Demolition of existing garage, side porch & roof level store & water tank & construction of a new side extension, new garage & second floor bedroom.

Broadbeach 39 Coastal Road Kingston

Thank you for your internet representation made on 4th June 2015 which has been recorded as '**an objection**' with the comments as follows:

1419 SK03A

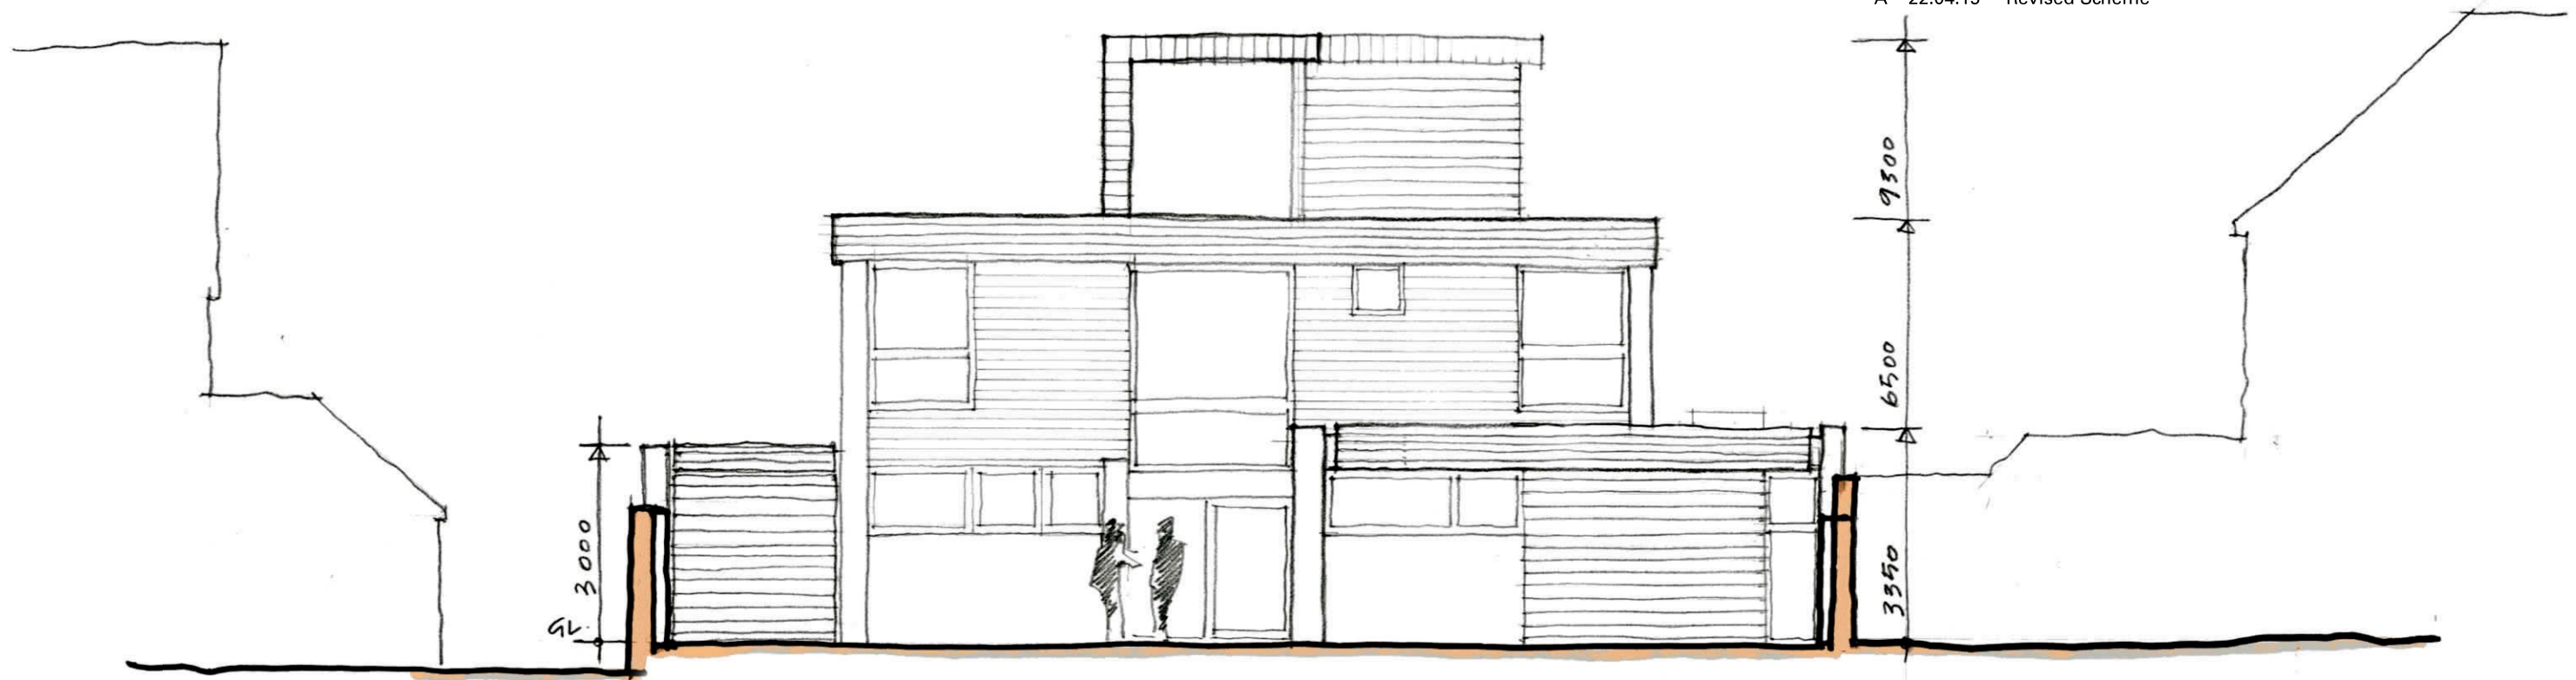
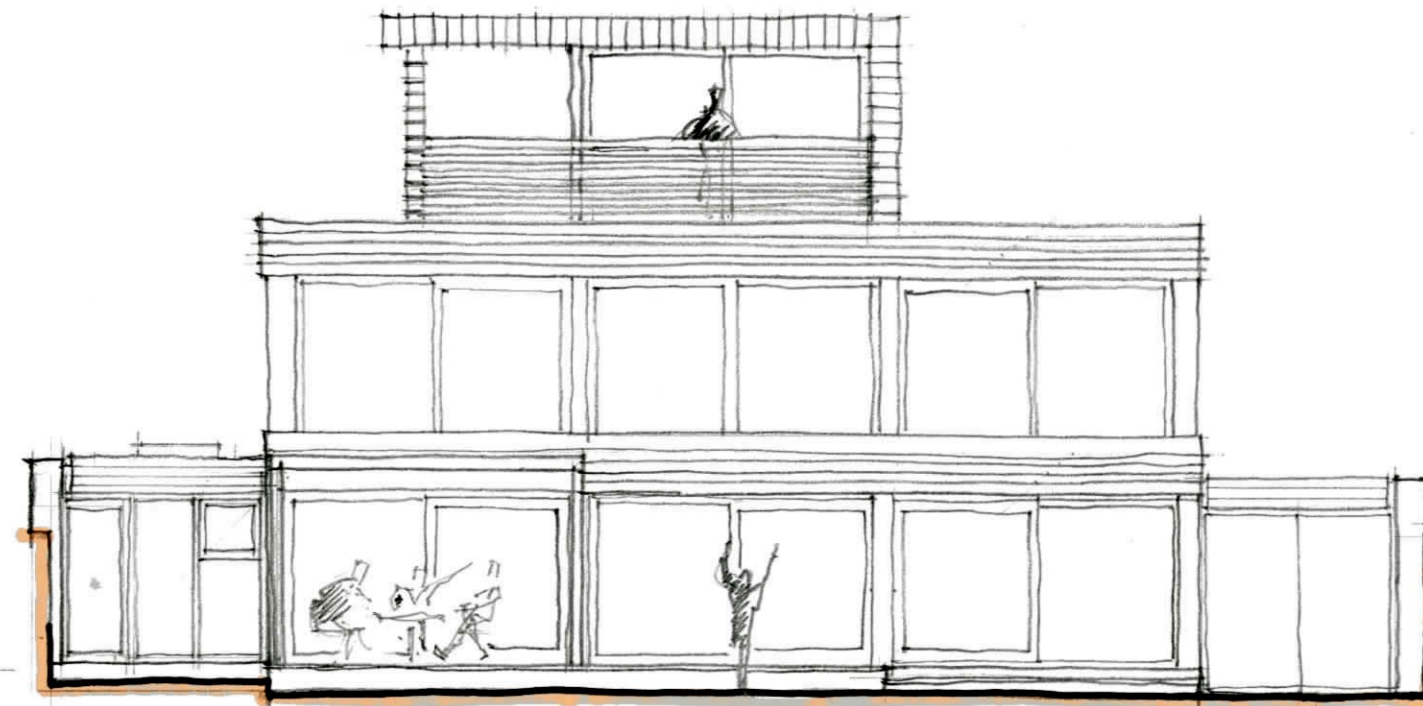
- 1. The windows in the additional storey would cause over-looking issues with neighbours (Neighbourhood Plan Policy 7.1.iv).*
- 2. The addition of a third storey creates a house that is not in keeping with the original scale and proportion of the original building. The resulting house would be unbalanced and unattractive. (Policy 7.2.iii).*
- 3. The use of zinc sheeting to face part of the third storey would introduce a new material to the structure which would not reflect the current character of the building. (Policy 7.2.iii).*

We consider that the proposed alterations, in particular the additional storey, would create a house of unbalanced and unattractive appearance, which would not be sympathetic to the character and appearance of the Parish. A third storey on a flat-roofed house is very different in its aesthetic effect from a third storey formed of rooms built in the roofspace of a pitched roof.(Policy 7.1.i).
